From: Amanda Scholes on behalf of Planning.Responses
Sent: 17 August 2017 12:17
To: Planning Scanning
Subject: FW: PLANNING APPLICATION REF. Y/40/17/OUT - BONHAMS, HOE LANE, FLANSHAM

Further Ecology Comments

App No: Y/40/17/OUT

Address: Bonhams Hoe Lane Flansham Bognor Regis PO22 8NP

BS Calculated root protection areas

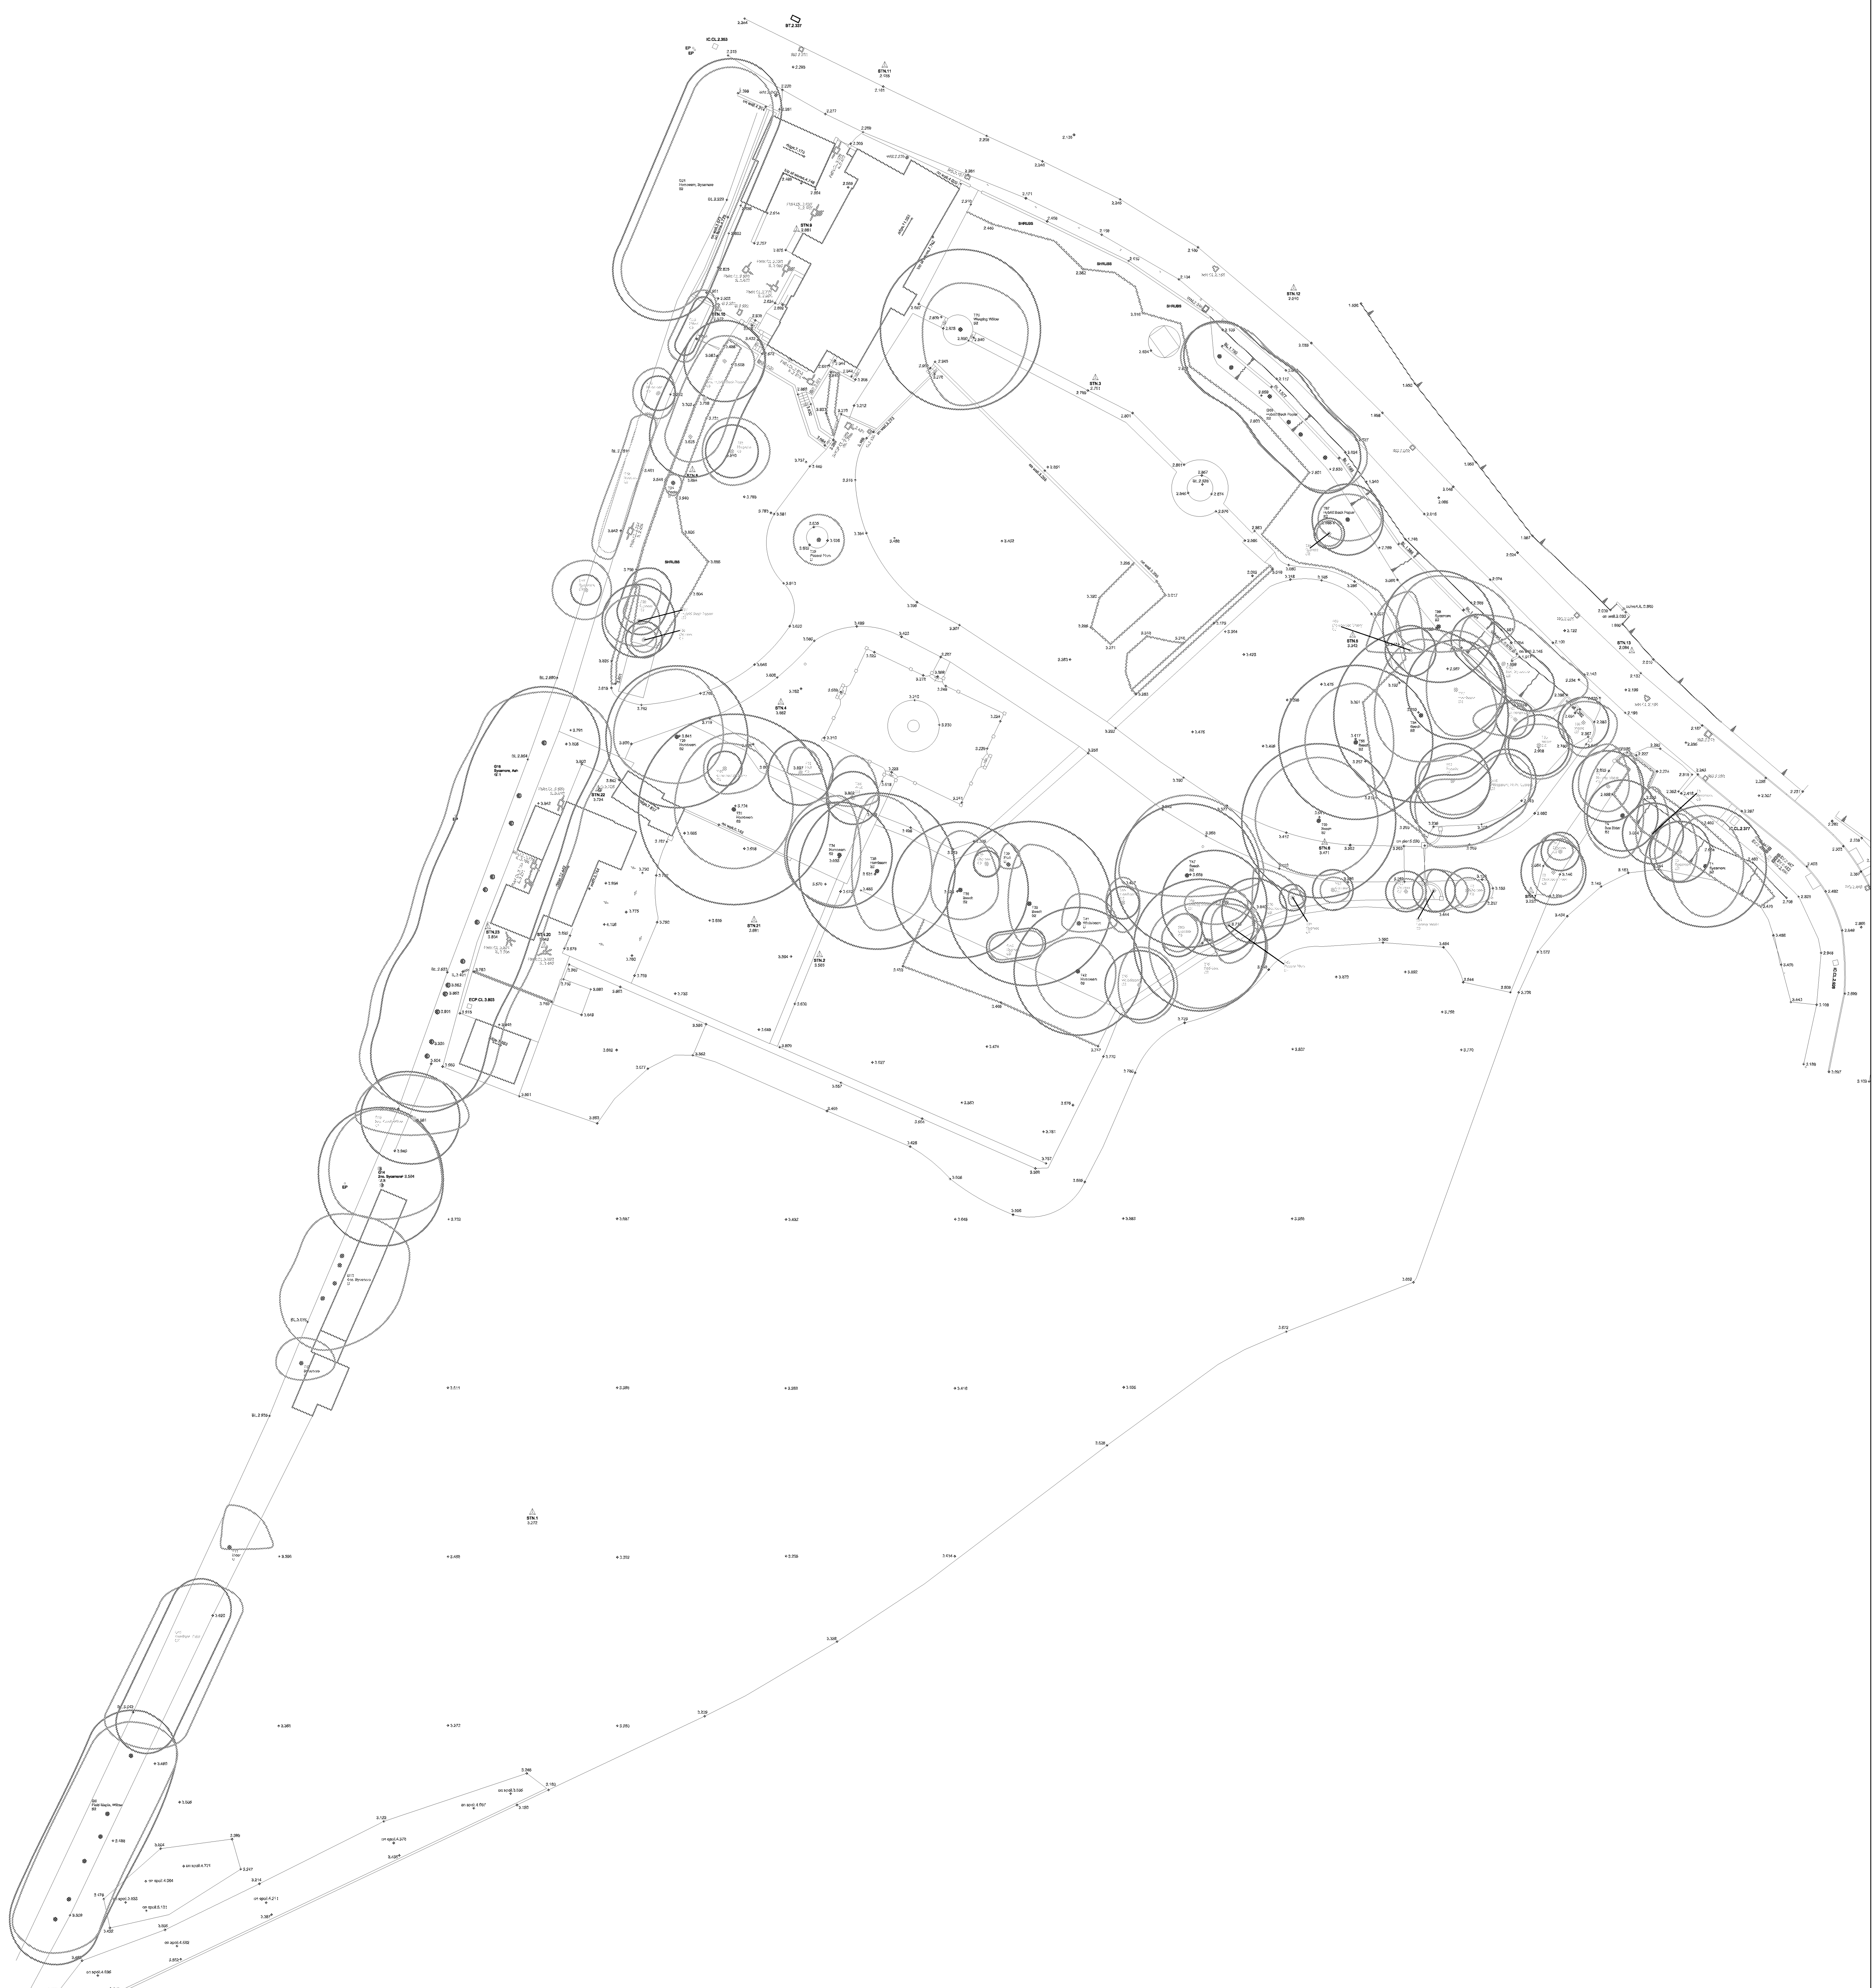
Surveys have shown that the Beech Tree (coded T47) on site supports a common pipistrelle bat roost. As detailed within the Bat Survey Report August 2017 the tree must be retained and a no light zone created around it where no lights will be directed towards this tree or within a 10 meter radius of it. A buffer should be created around this tree and fencing used during the construction period to ensure this area remains undisturbed.
